Laurie Leader - Re: BP#2015-00713 352 Warren Avenue - Plan review for change of use building permit

I am handling the plan review for the change of use building permit for 352 Warren Avenue.

PROPOSED USE: HAIR SALON
 352 WARREN AVENUE
 UNIT #9 1ST FLOOR

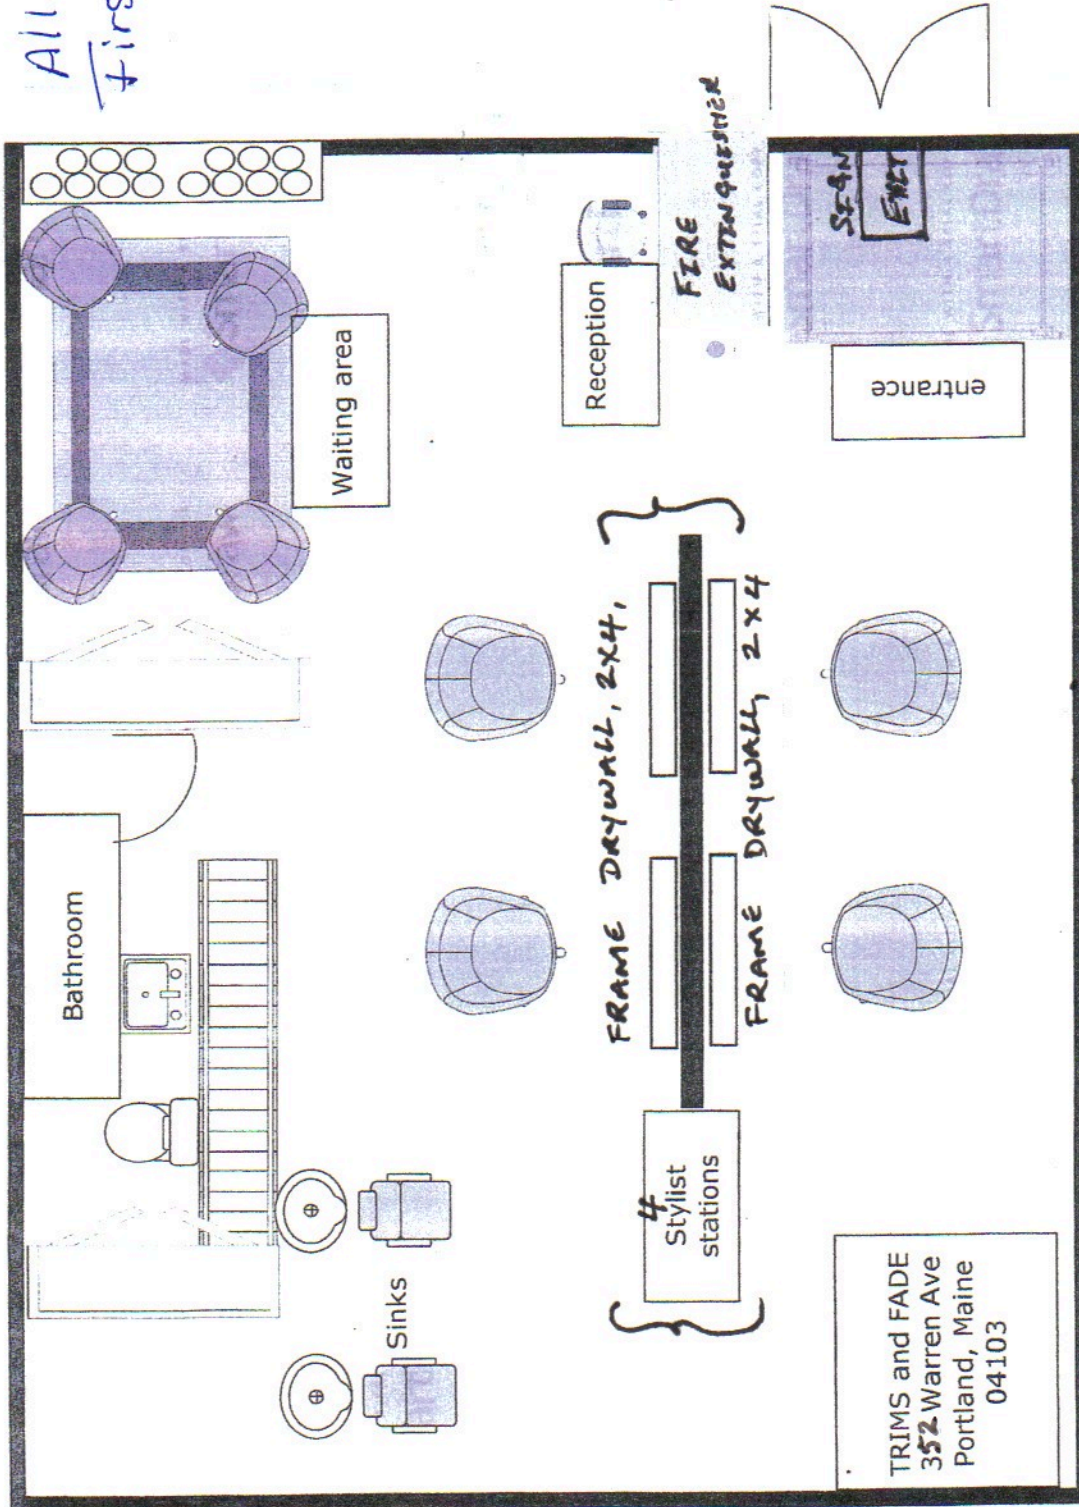
1. Have the sink fixtures and plumbing pipes installed in the salon?
2. Did the plumber file for a permit? Was the work inspected?

The plumber has not pulled a permit as of now. He will do so as soon as I receive the building permit. I have contracted D&P plumbing to do the work. I will notify him immediately to pull a permit for the project.
